53 SILVERDALE GARDENS HAYES UB3 3LN

PLANNING RESPONSE

This statement is produced in support of proposed side extensions to create an additional dwellings at 53 Silverdale Garden. Also this document is produced in response to refusal points raised in previous application (LBH ref no. 22856/APP/2021/2634

| Rev                                                     | Date     | Note               |
|---------------------------------------------------------|----------|--------------------|
| PROPOSED ELEVATION 1 OF 2                               |          |                    |

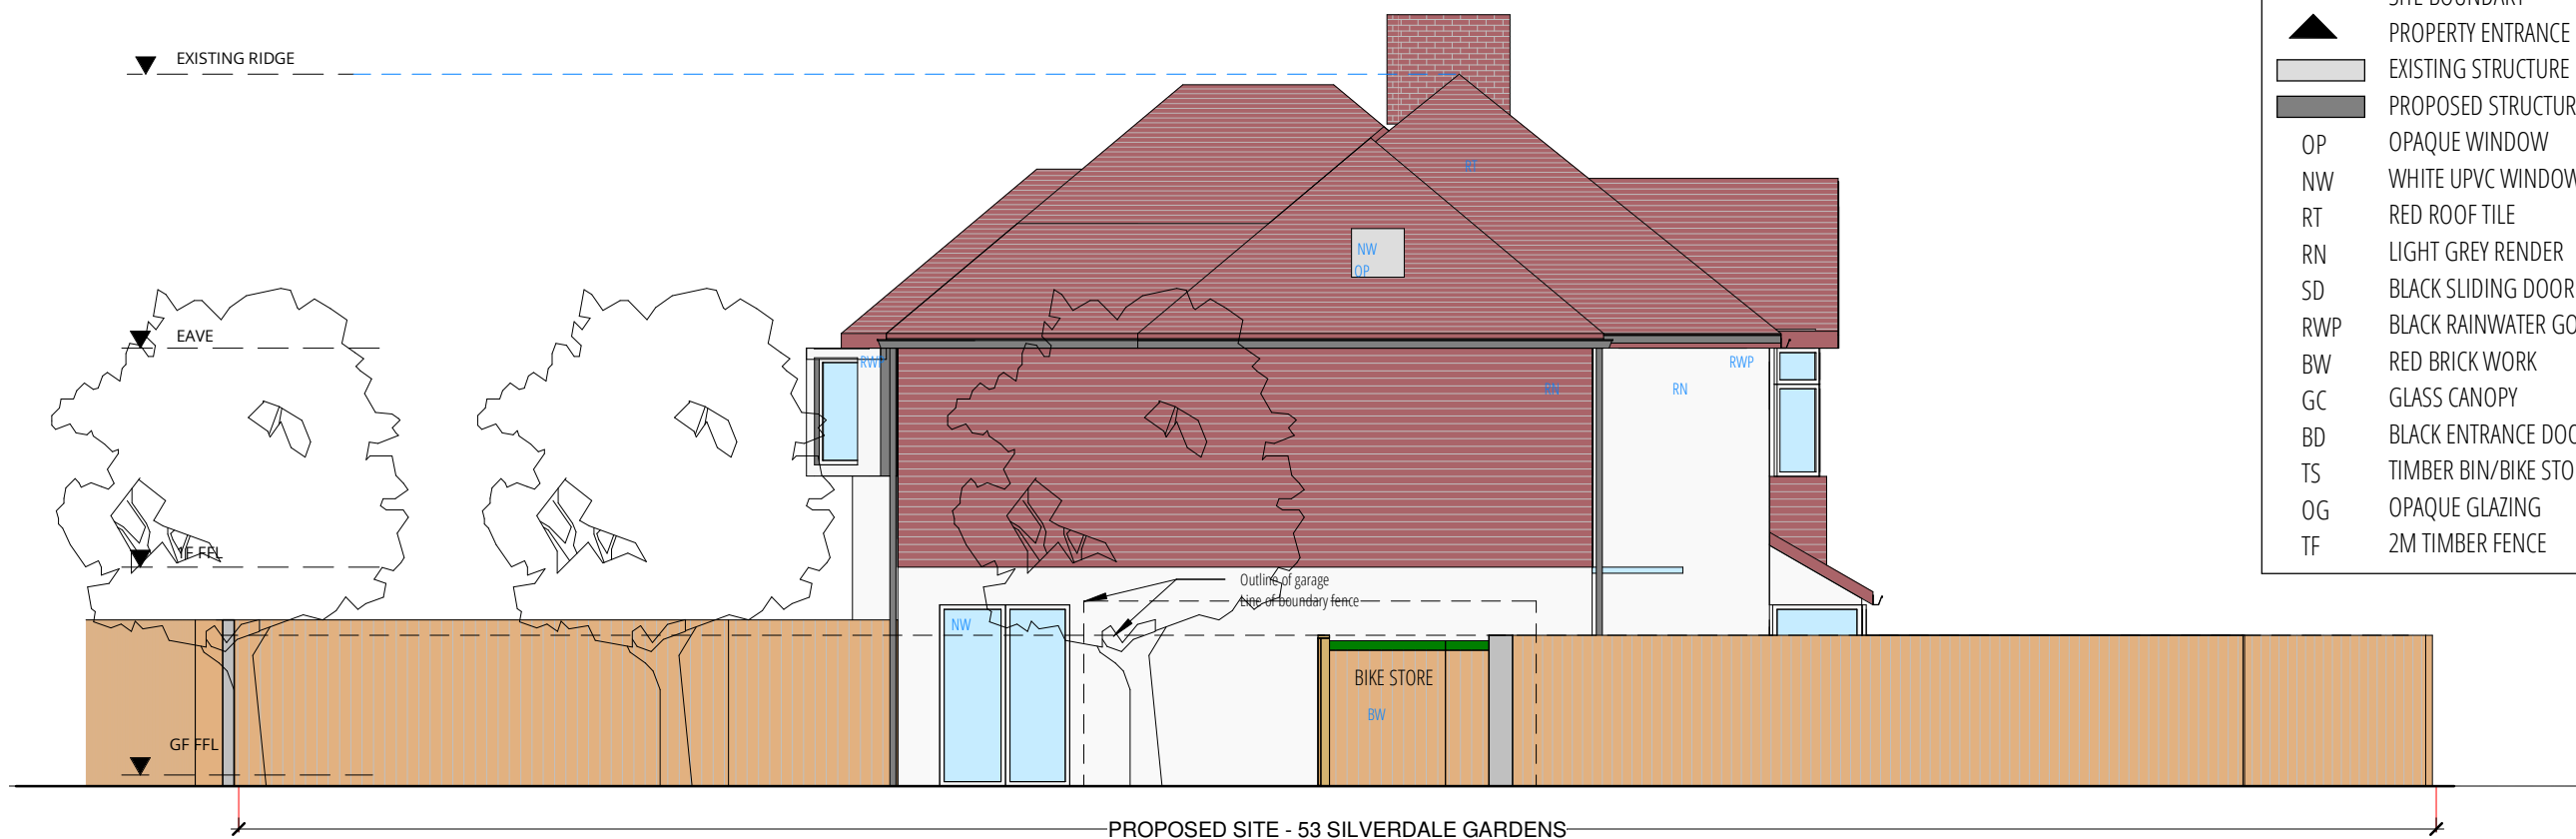
- 1 - The proposed part single storey, part two storey side and rear extension, by reason of its bulk, width and design would fail to form a subordinate addition to the host dwelling which harmonises with its original size and architectural composition. The proposed extension would therefore be detrimental to the character, appearance and visual amenities of the dwelling and street that the dwelling is part of. Therefore the proposal would be contrary to Policy BE1 of the Hillingdon Local Plan: Part One - Strategic Policies (November 2012), Policies DMHB 11, DMHB 12 and DMHD 1 of the Hillingdon Local Plan: Part Two - Development Management Policies (January 2020), as well as policies D3 and D6 of the London Plan and paragraphs 130 (a) and (c) of the NPPF (2021).

1.2 PROPOSED MATERIAL & VISUAL BALANCE: Furthermore the first floor two storey extension has been cladding in roof tiles that match existing building & step down of extension roof in order to help it to formed subordinate addition (FIG 2).

FIG 2: Proposed front elevation with roof tile cladding to 1F wall (refer to drawing A120).
